**Subject:** RE: AB/54/22/DOC

However, it is clear from the response provided by the applicant that two of the consultation comments (1 and 4) have not been satisfactorily addressed. **On this basis I recommend that the application is refused.** It is suggested

SCALE	DRAWN	DATE
1:200 @ A1	RT	MAR 22
CHECKED	PASSED	REV.
NG	NG	C4
DRAWING NO.	SDP DRAWING NO.	
OKA097_1101	E19-003-1101

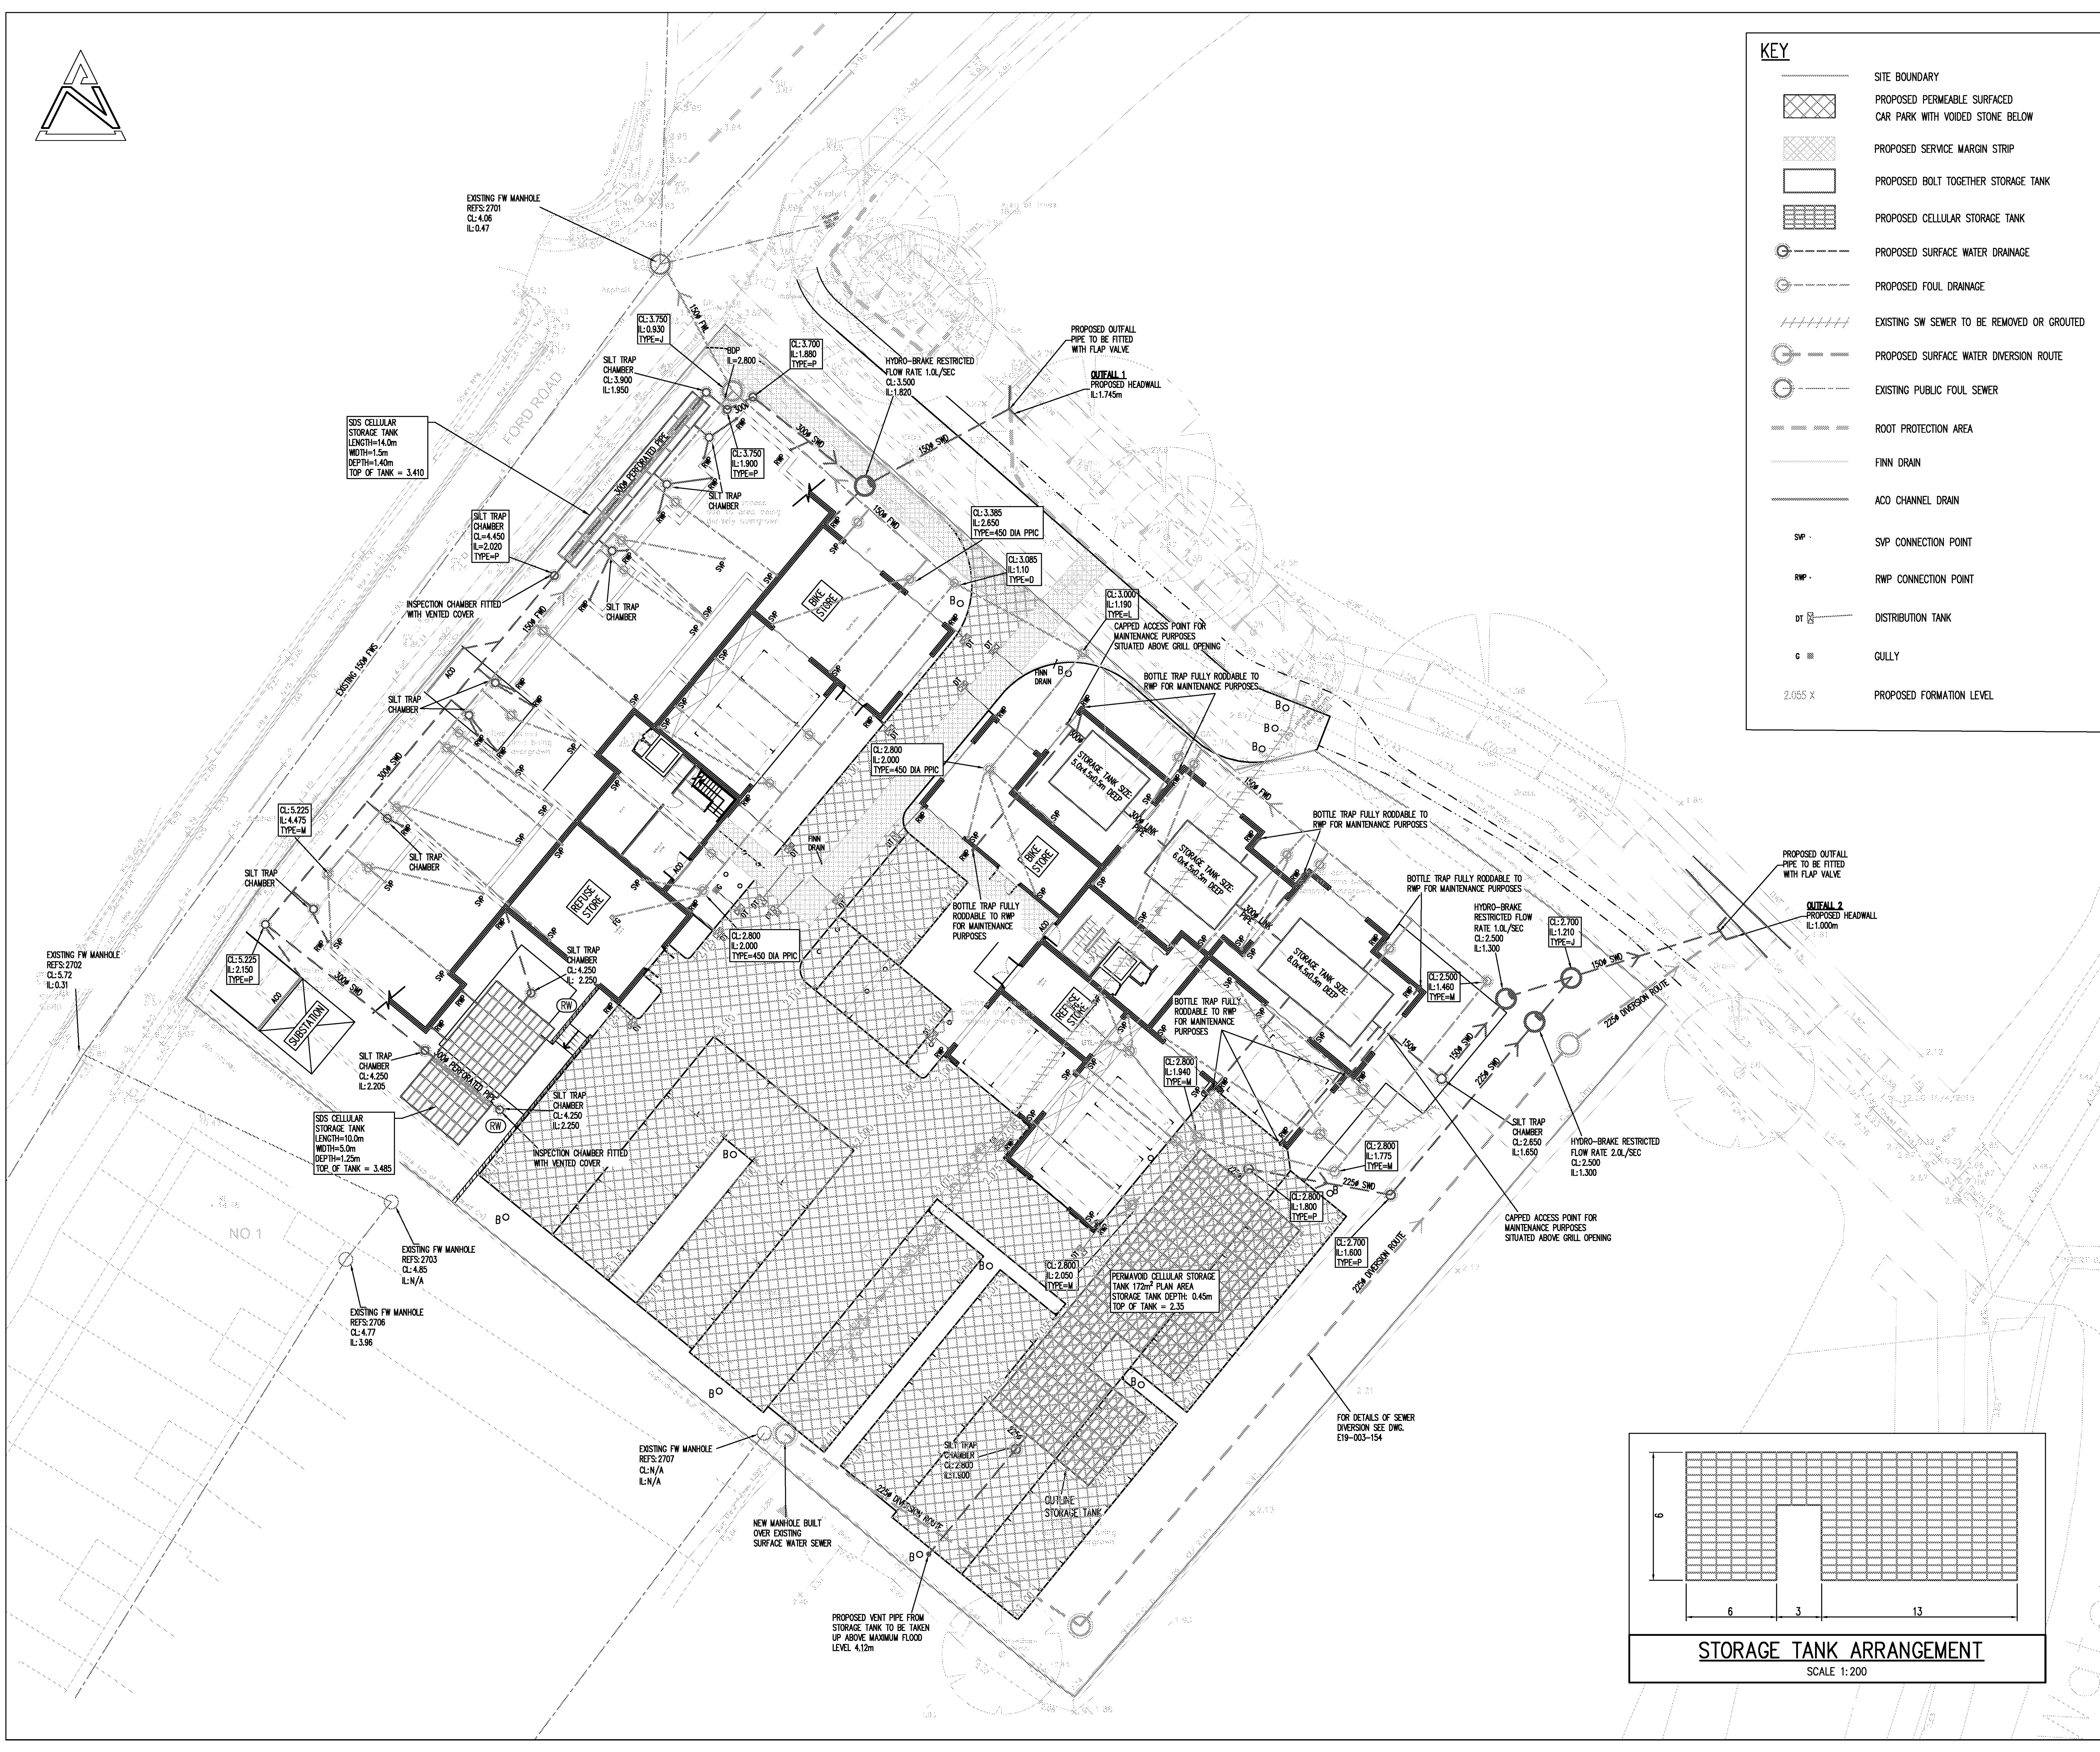
2. Surface and bed levels for the proposed permeable surfacing should be included on the drainage drawing.

9. A justification for why vents have not been included within the tank designs that are not vented should be provided. If vents are required for all tanks, then they should be included on the drawings. Vents should be located at a sufficient elevation to prevent floodwater ingress into the tanks (i.e. above the design flood level) unless there is good reason why this cannot be achieved and any impacts of the vents being below this level are fully considered.

13. If the drainage calculations only account for run-off draining from impermeable surfaces, then the calculations should use a CV of 1.0.

14. The drainage calculations include a 10\*2 (20)m<sup>3</sup> per ha additional storage volume, which is not included within the design. A justification for this value should be provided, or this value reduced to 0.

The base level of the voided stone below the permeable paving has been added to the plan E19-003-1101. The surface level is 2.80m AOD and is shown on the levels plan E19-003-1102 attached.

Currently the tanks are vented in the usual way into adjacent manholes as per the manufacturer's requirements. Vents have been added to the drainage layout E19-003-1101 and show a level above 4.12m AOD.  
*Not assessed – will be checked at next DOC.*

Noted and the calculation re-run using a CV value of 1.0. This has revised the attenuation and the drainage drawing E19-003-1101 has been updated.

SCALE	DRAWN	DATE
1:200 @ A1	RT	APR 22
CHECKED	PASSED	
NG	NG	
DRAWING NO.	SDP DRAWING NO.	REV.
OAK097_1102	E19-003-1102	C2

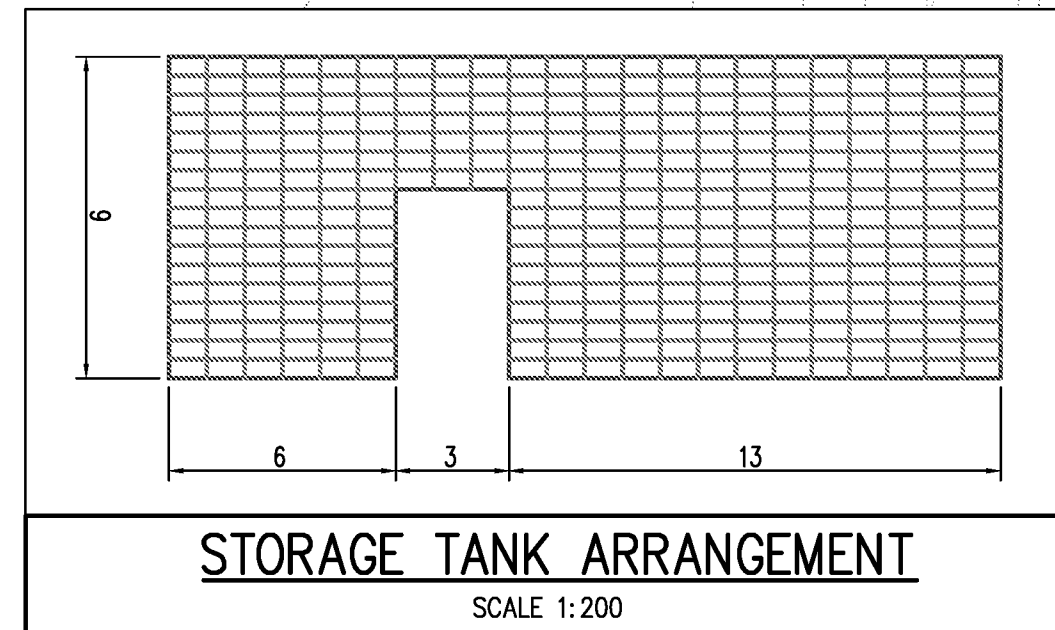
5. During earlier discussions with the LPA it was acknowledged that remediation for onsite contamination resulted in raised ground levels and this is also stated in Condition 11 of the originally approved application. As there is potential for this to conflict with the drainage design and proposed level of the car park required as flood compensation, we require confirmation that the agreed car park level of 2.80m AODN will be achieved.

- The levels on the drainage drawing suggest land raising has not been carried out, however, it is unclear if the 2.80m level will be achieved across the entire permeable car parking area.
- The applicant should confirm whether land raising has been carried out as per the contamination mitigation strategy or not been carried out as per the drainage design drawing.

The preliminary remediation work levels are above the 2.8m AOD agreed level. However, further detailed remediation works are to be carried out and this will enable the final level of 2.80m AOD to be achieved in accordance with the planning approval.
